Our reference: ECM: 8965012
Contact: Gavin Cherry
Telephone: 4732 8125

28 January 2020

SSD 7348 - MOD 2 - Further Amendments to Concept Plan and Stage 1, Oakdale West Precinct

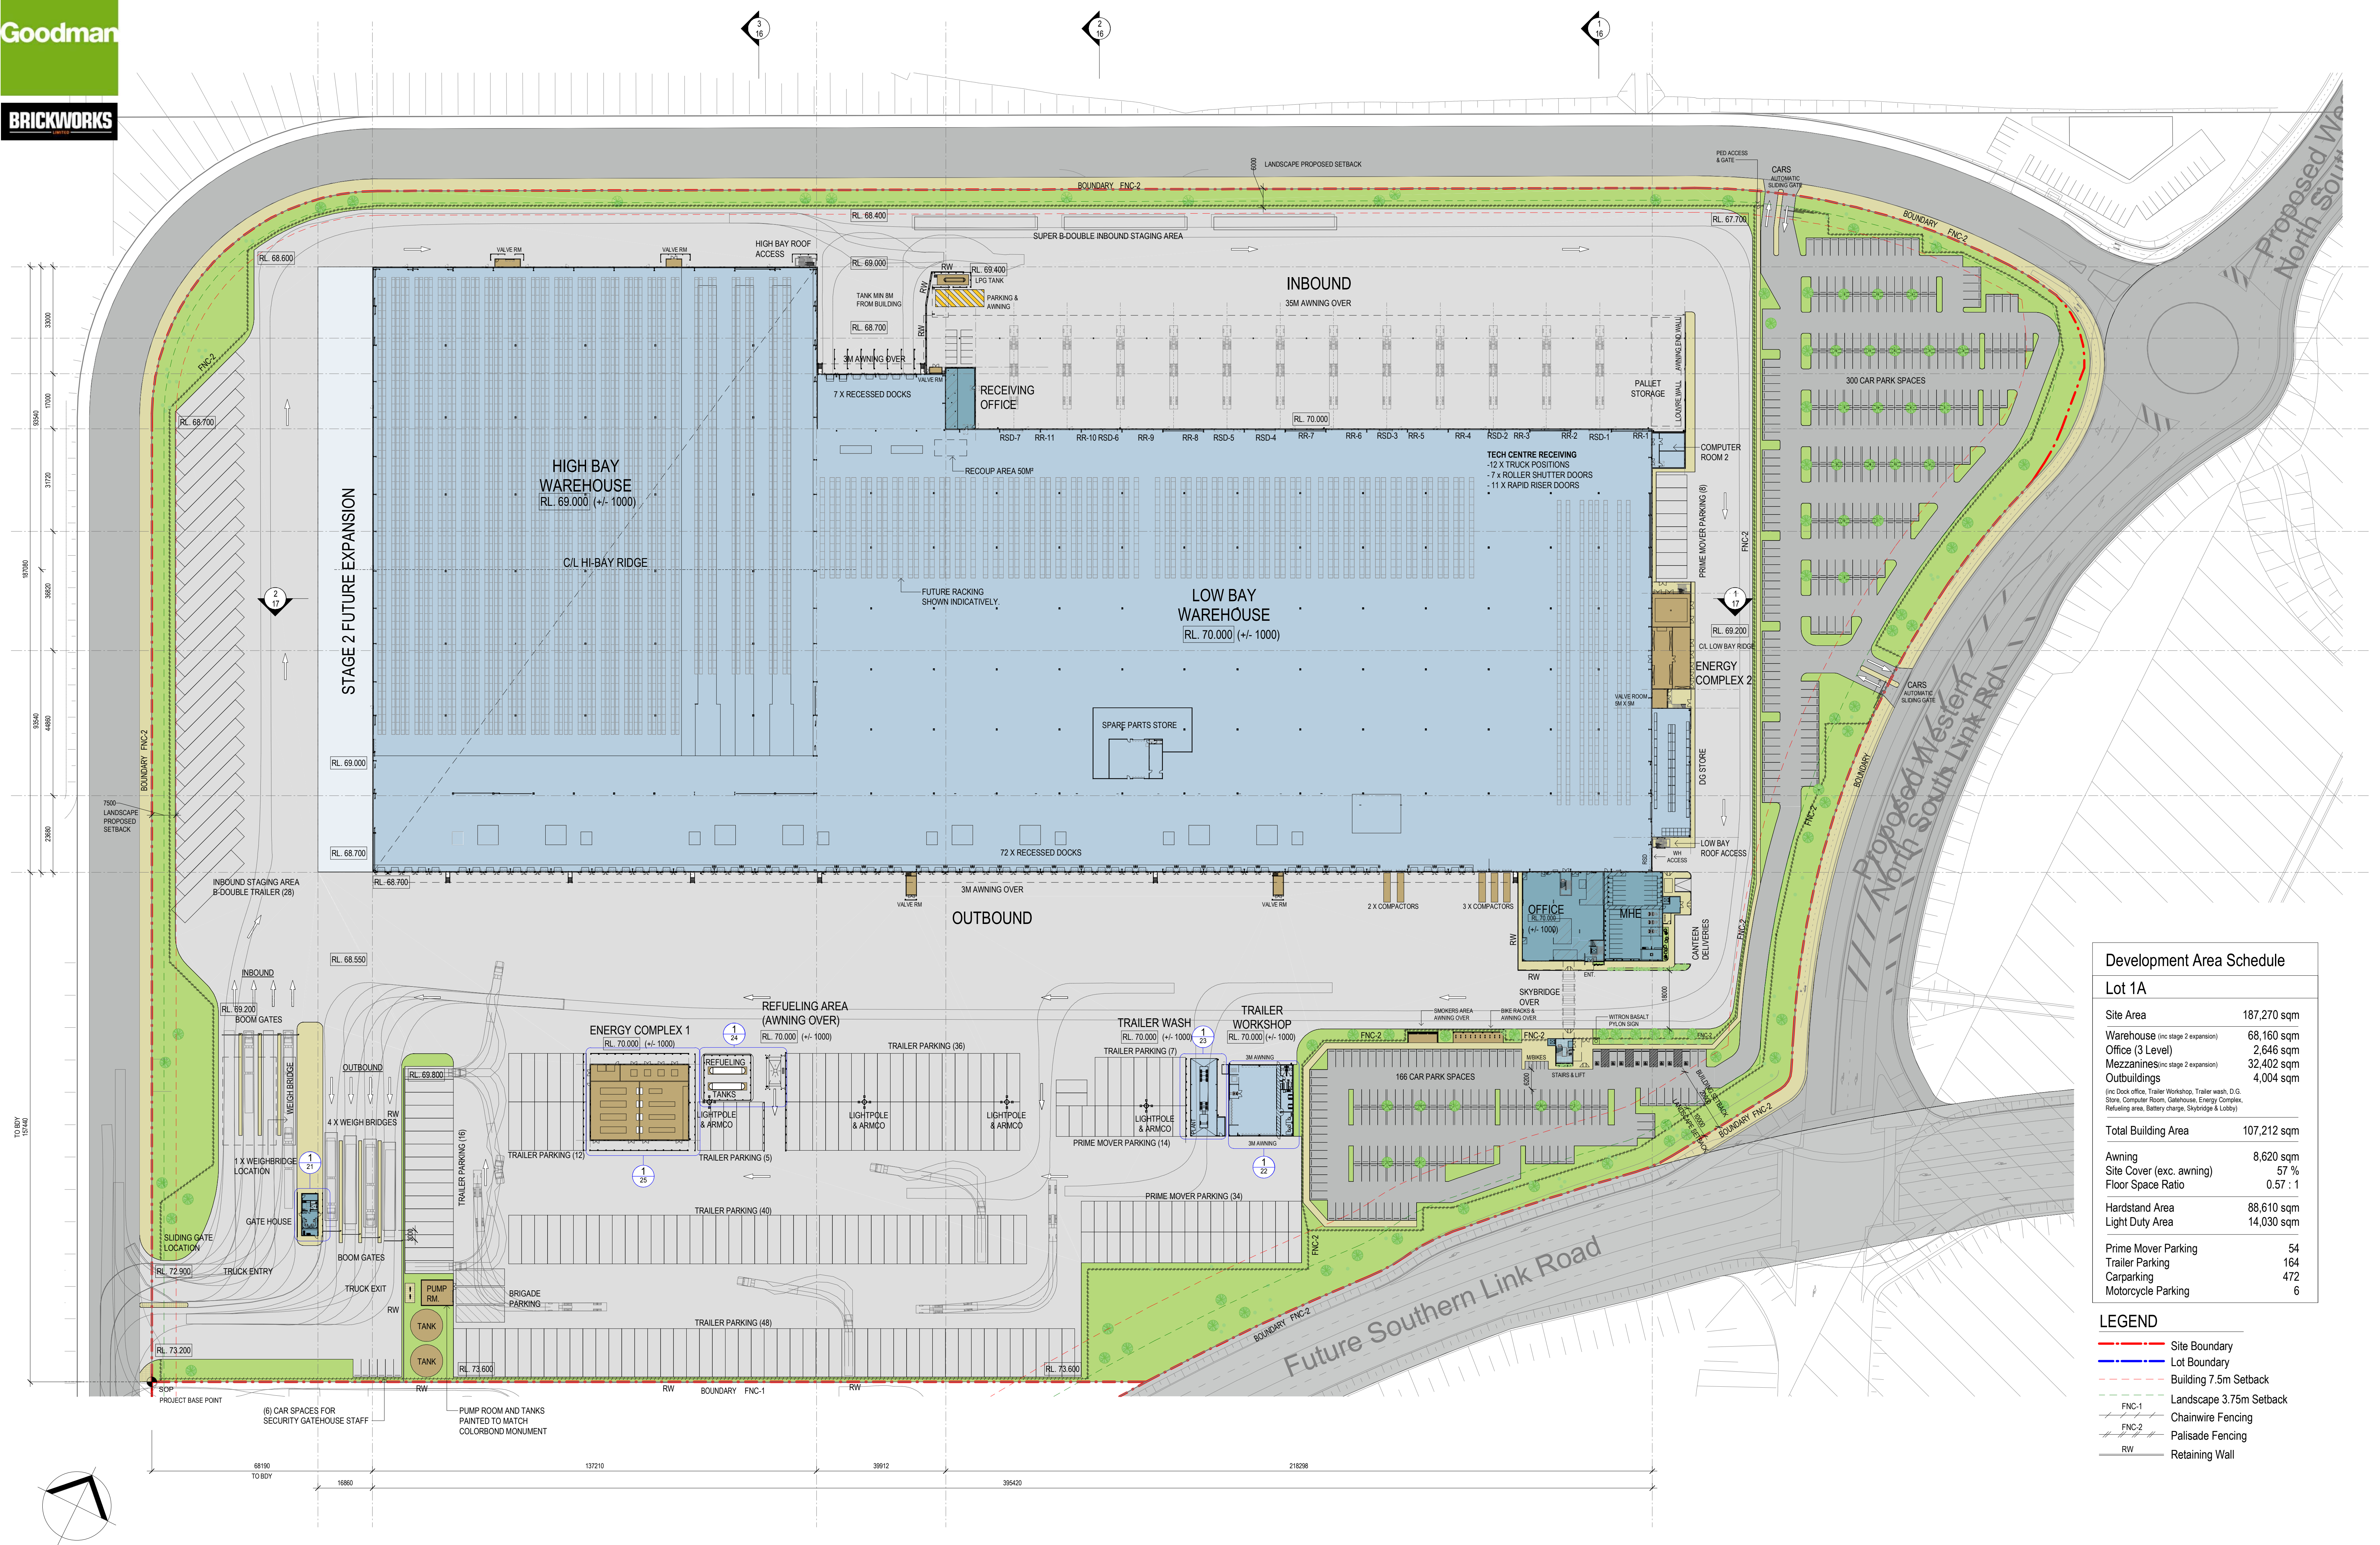
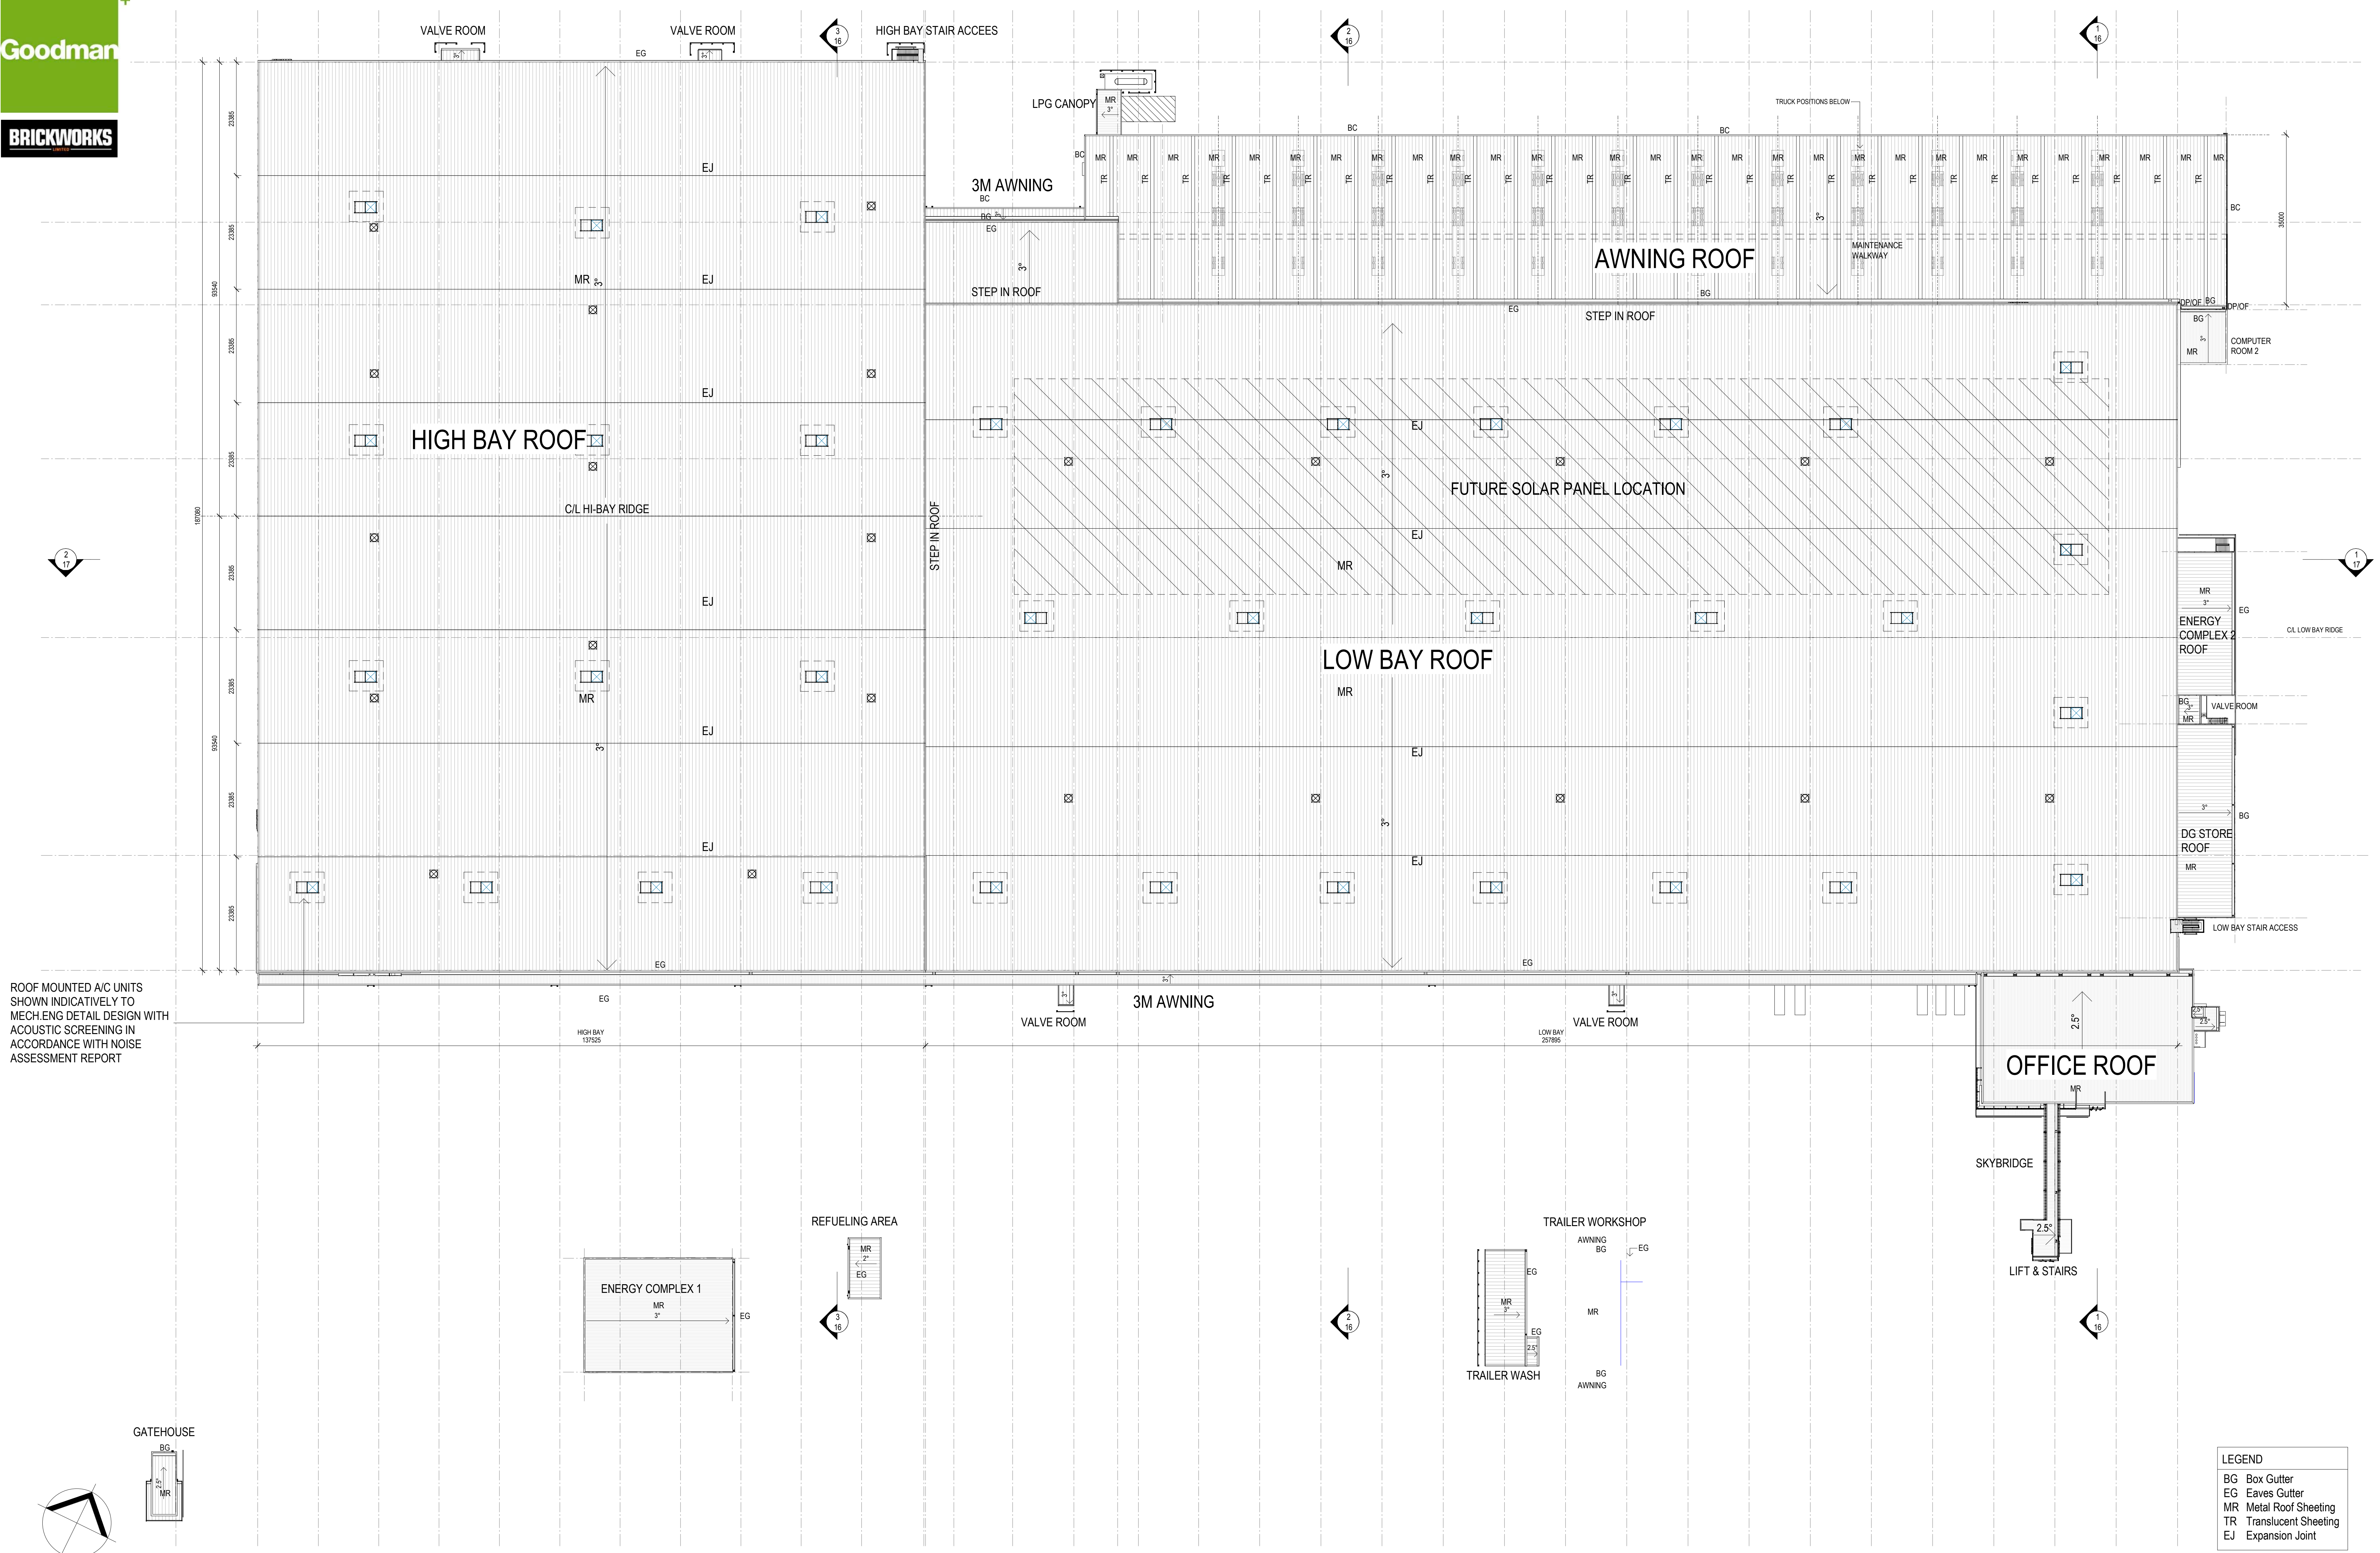
The proposed amended car park arrangement includes proposed driveway access off the Western North South Link Road which is not supported by Council's Development Engineers and Traffic Engineers.

It has been requested that driveway access arrangements be amended to provide access off Estate Road No 1 only.

If there are any concerns with respect to queueing, then the driveway could be widened to accommodate one entry lane and two exist lanes (a left turn lane and a right turn lane).
